From: Bloomer, David <David.Bloomer@lancashire.gov.uk>
Sent: 14 December 2018 11:55
To: Harriet McCartney
Cc: LHS Customer Service; planning
Subject: App3/2018/0984 Deli Solutions , Lincoln Way , Clitheroe

Drawing Title
Proposed Site Plan
Deli Solutions (1:200 Scale)

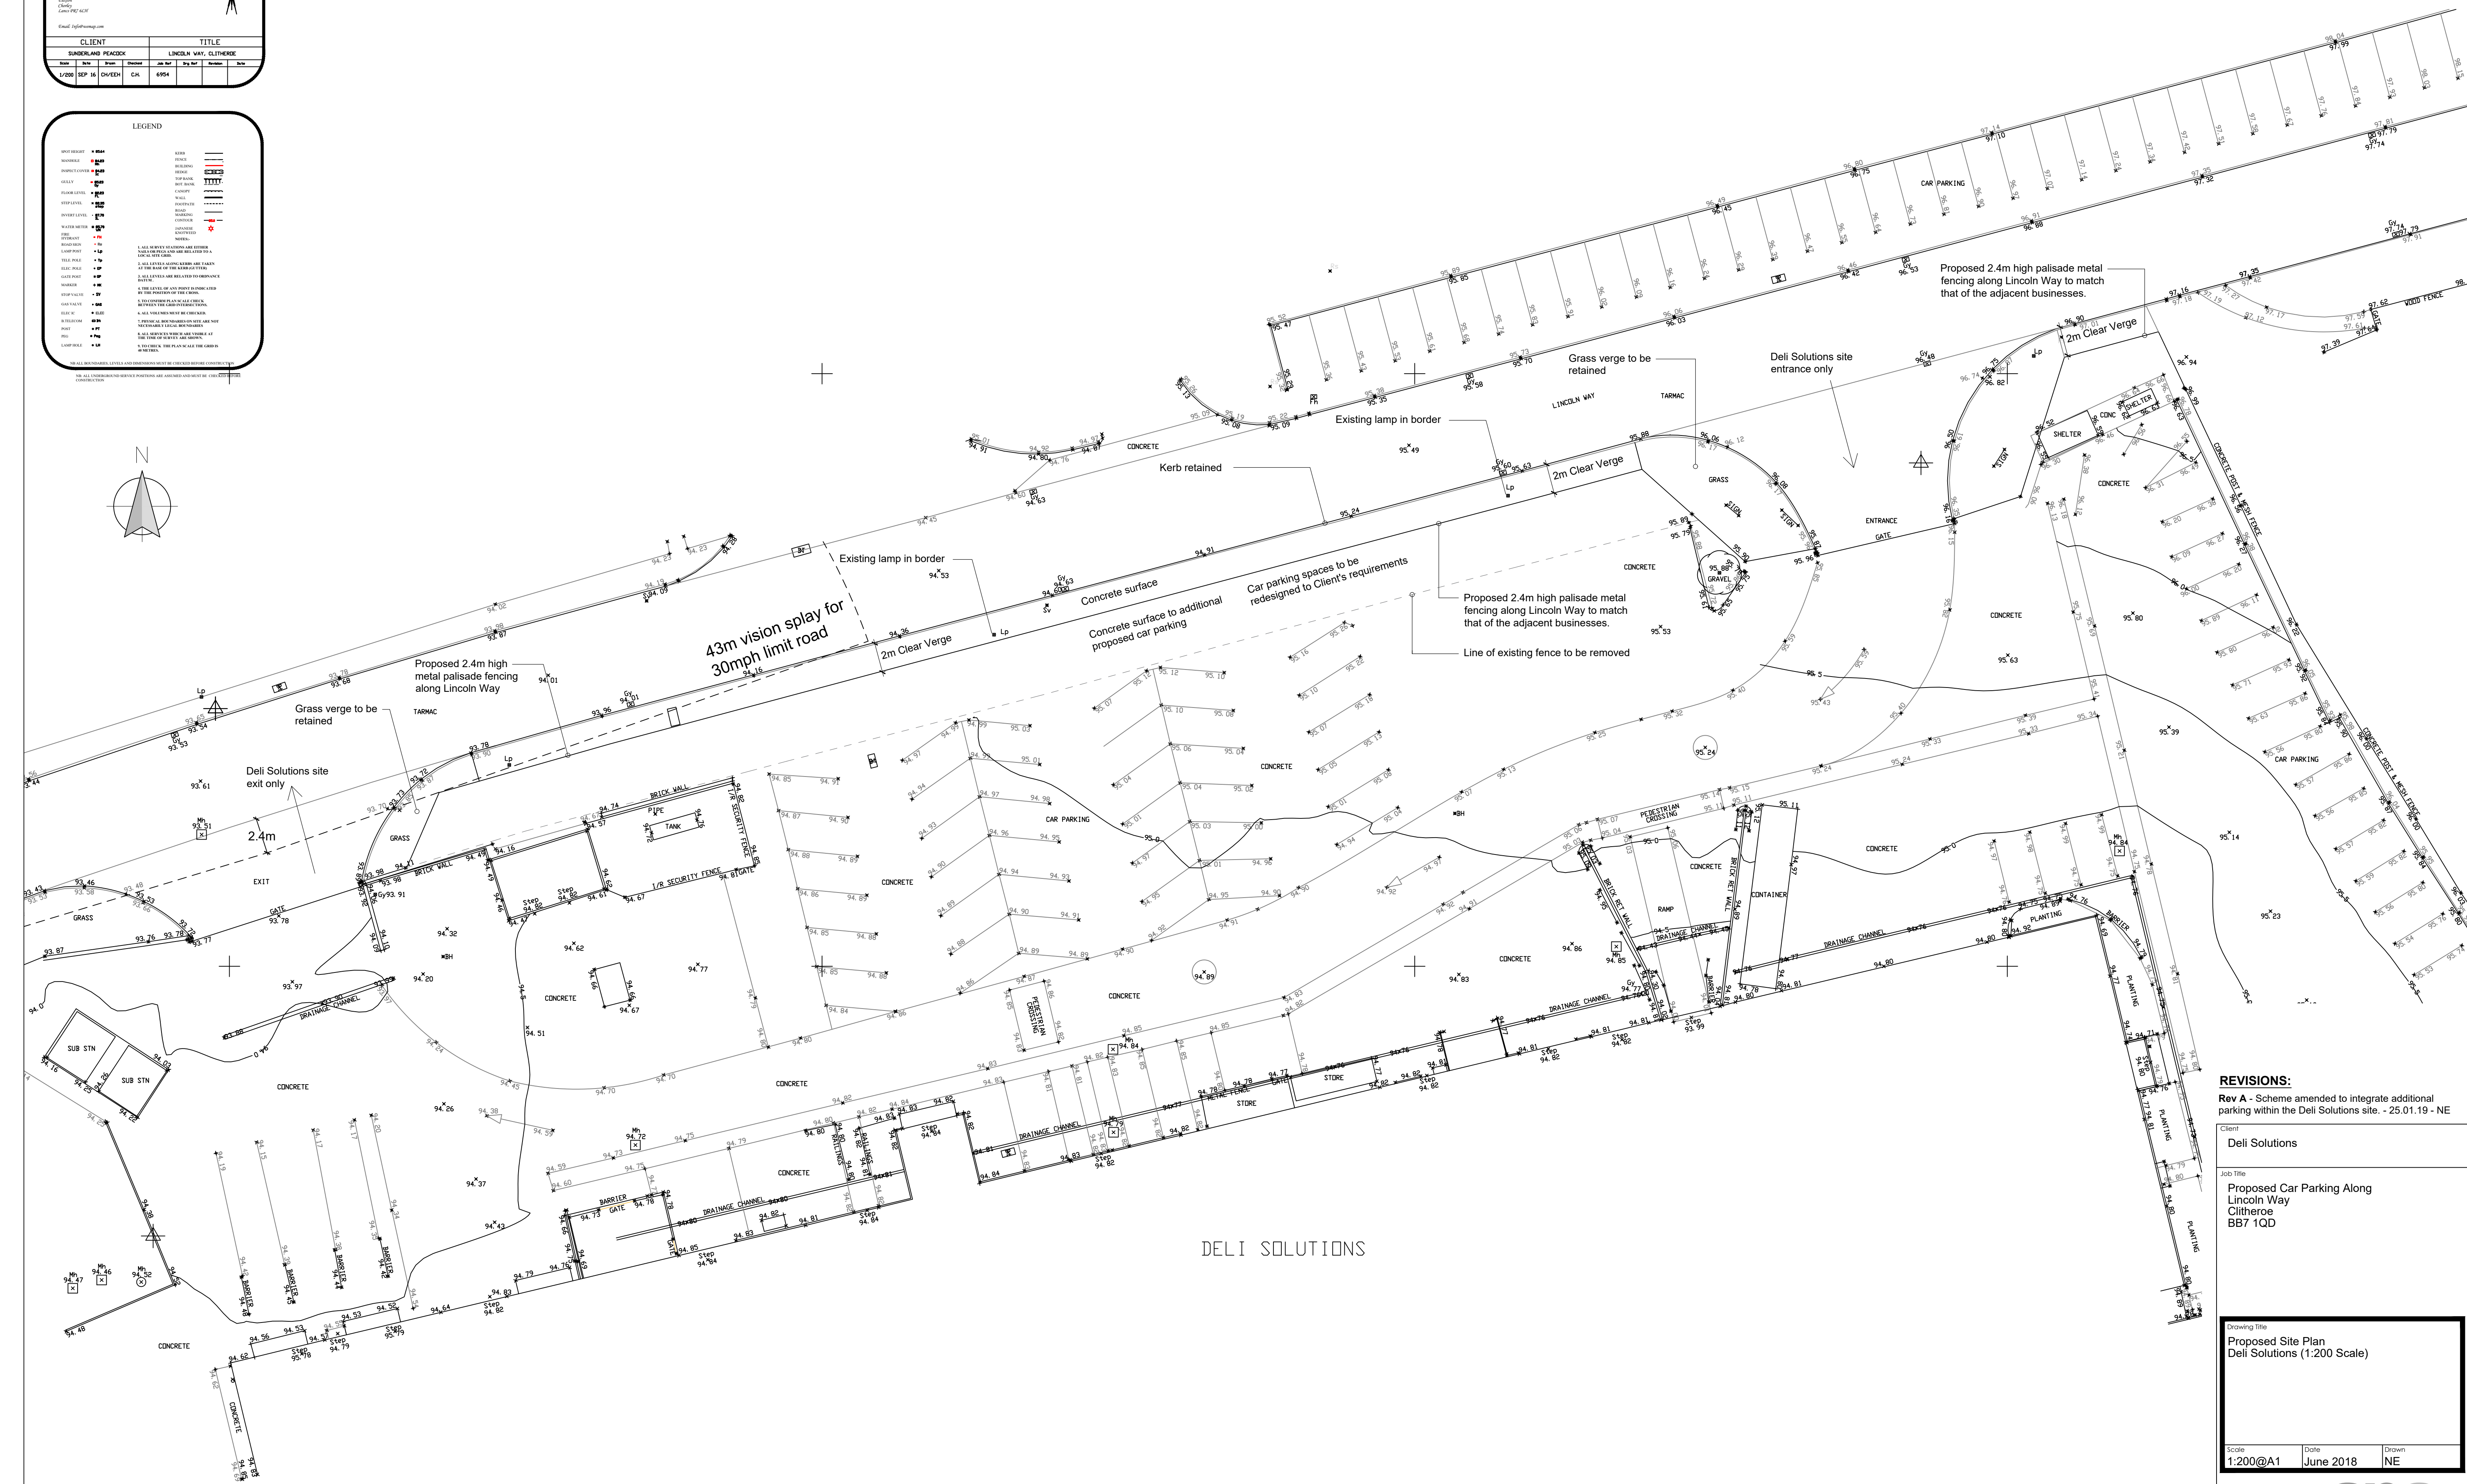
The proposed additional parking provision situated alongside Lincoln Way has not taken into account the extent of the adopted highway and as such the proposed parking areas encroach into the public highway. Such encroachment would not be permitted and unless the applicant can amend the proposals to avoid this conflict then I would have to recommend that the application be refused .
